**FLOOD RISK RELATED COMMENTS ON DEADLINE 3
SUBMISSIONS IN RESPECT OF SCOTTISH POWER
RENEWABLES EA1N AND EA2 PROJECT ONSHORE
WORKS NEAR FRISTON**

Report Title: Flood Risk Related Comments on Deadline 3 Submissions in Respect of Scottish Power Renewables EA1N and EA2 Project Onshore Works near Friston

Job: SASESFRA
Report Number: 210110
Version: v.02
Issue Status: Draft
Prepared by: Clive Carpenter
Issue Date: 12th January 2021

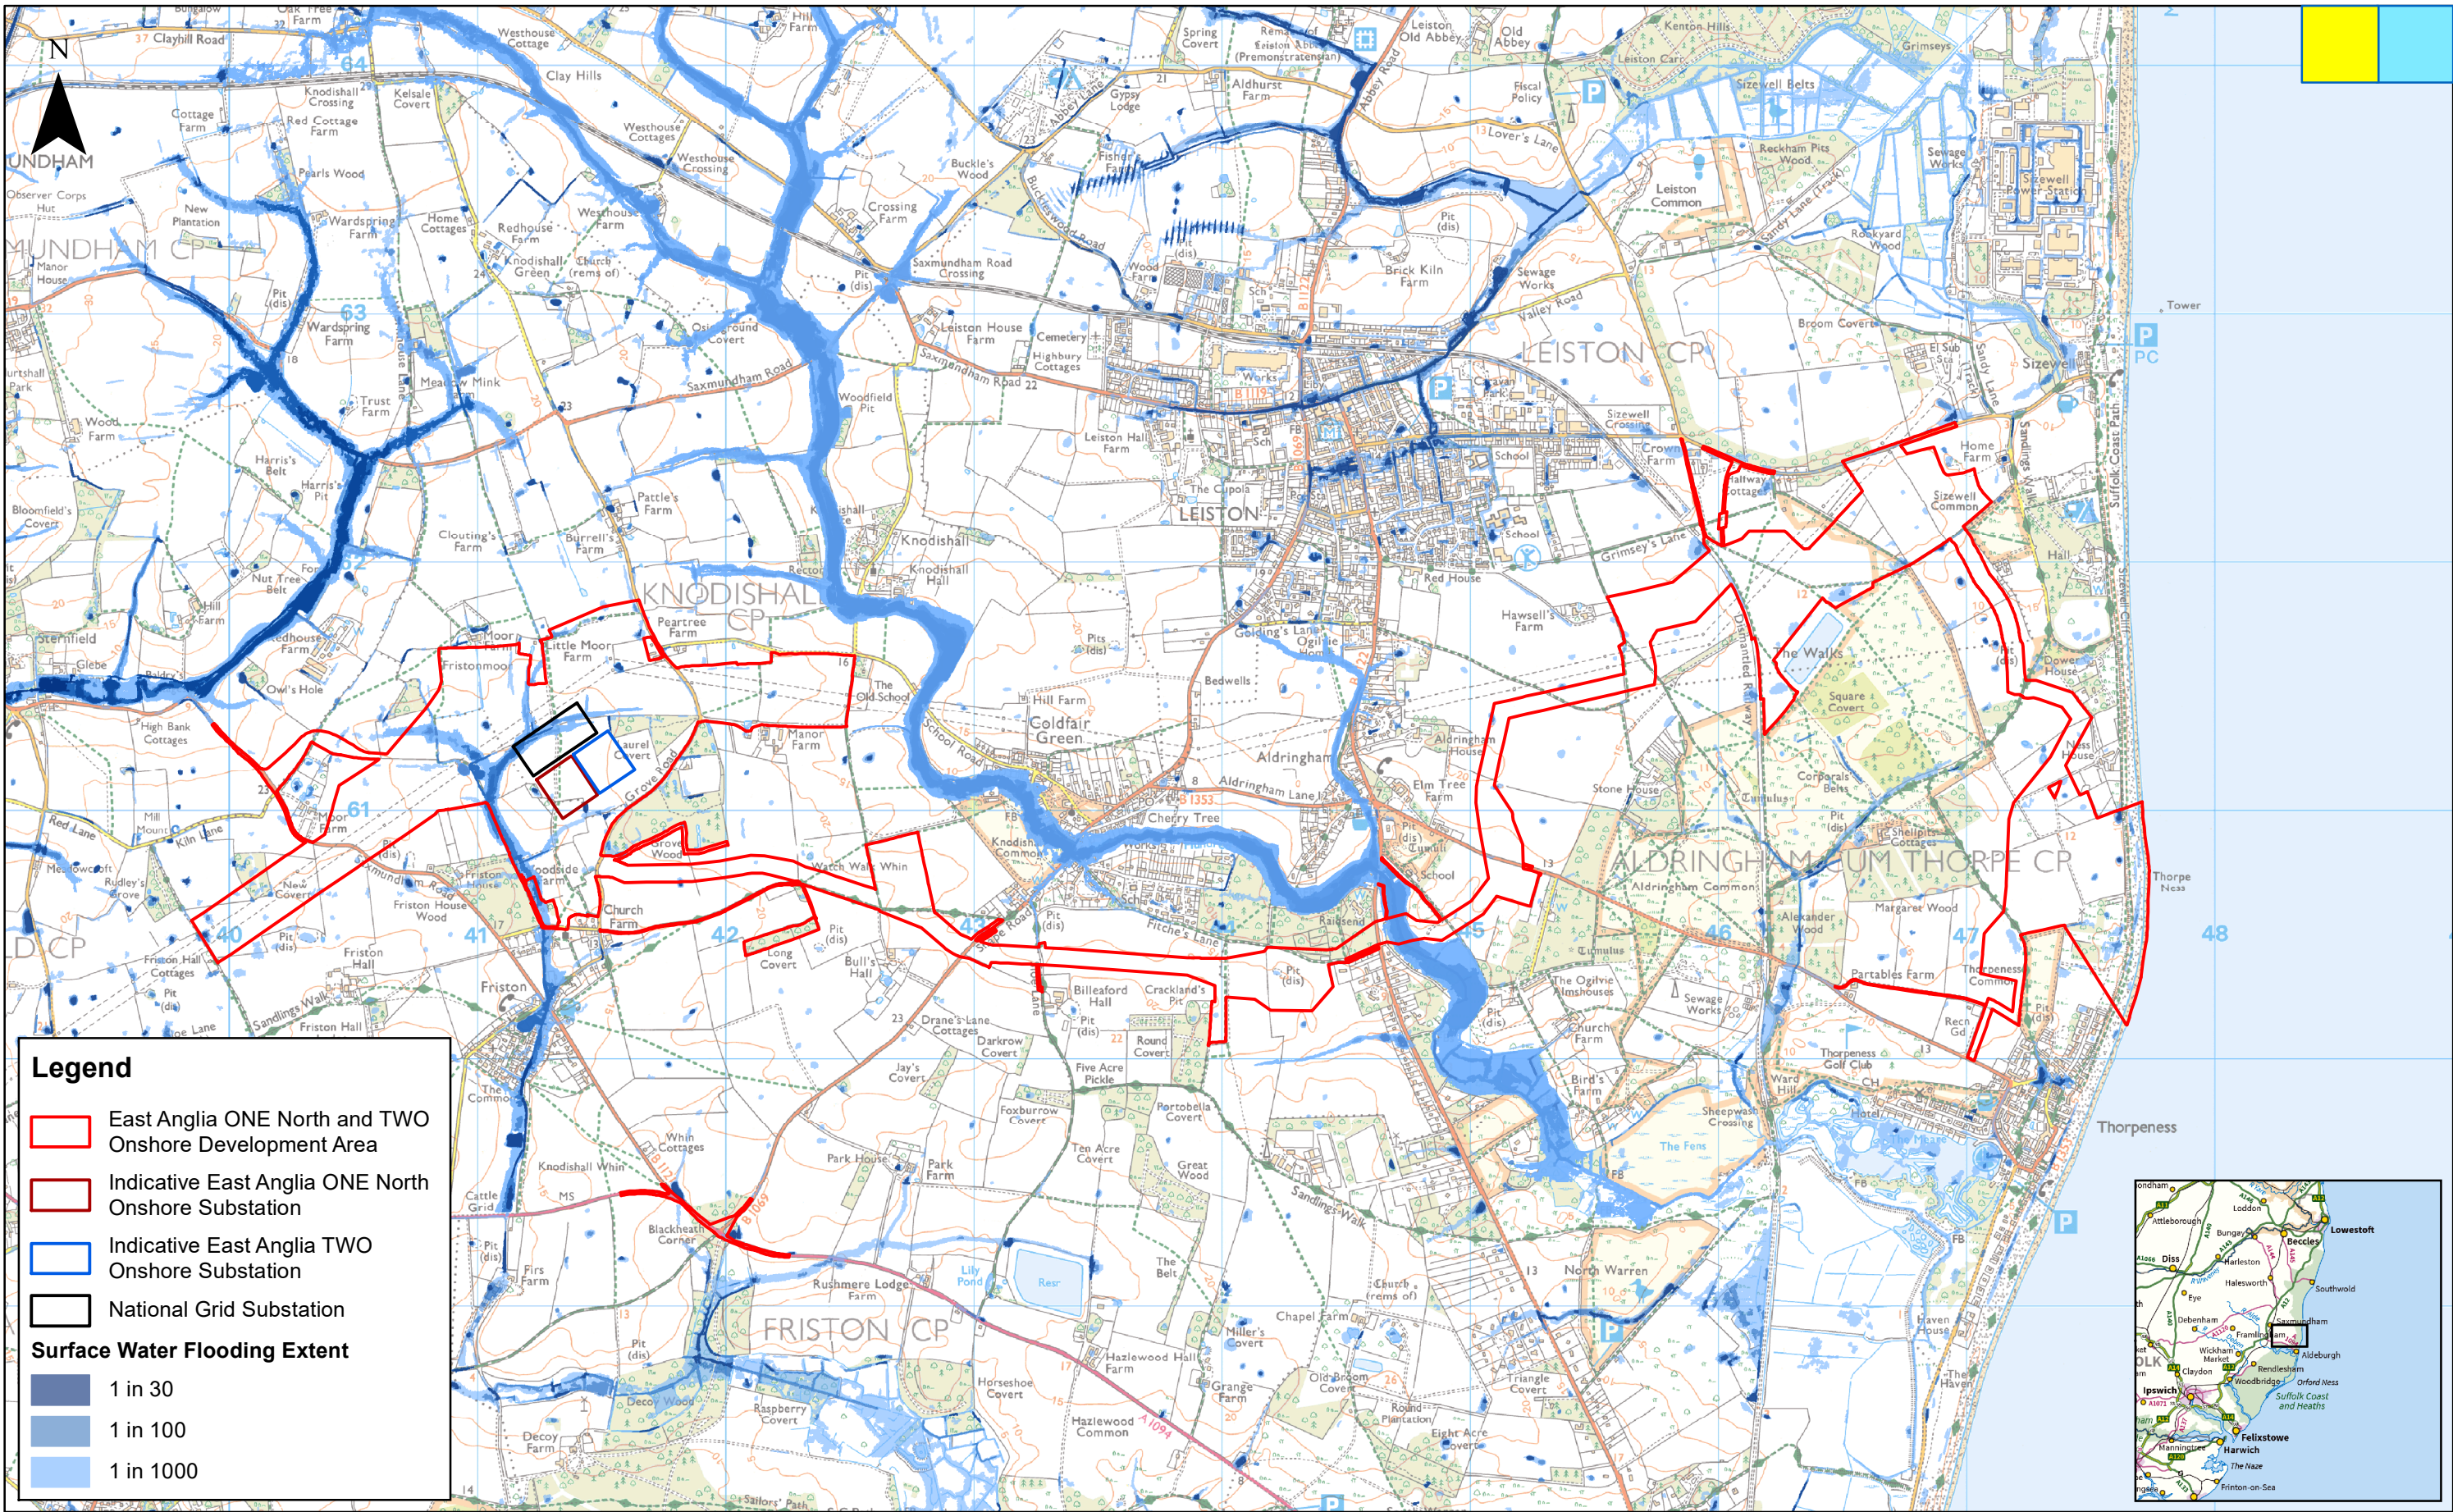
The Applicant has also included a surface water flood risk map, which clearly shows the overland flow routes hydraulically linking the proposed development site to the water courses flowing through Friston Village.
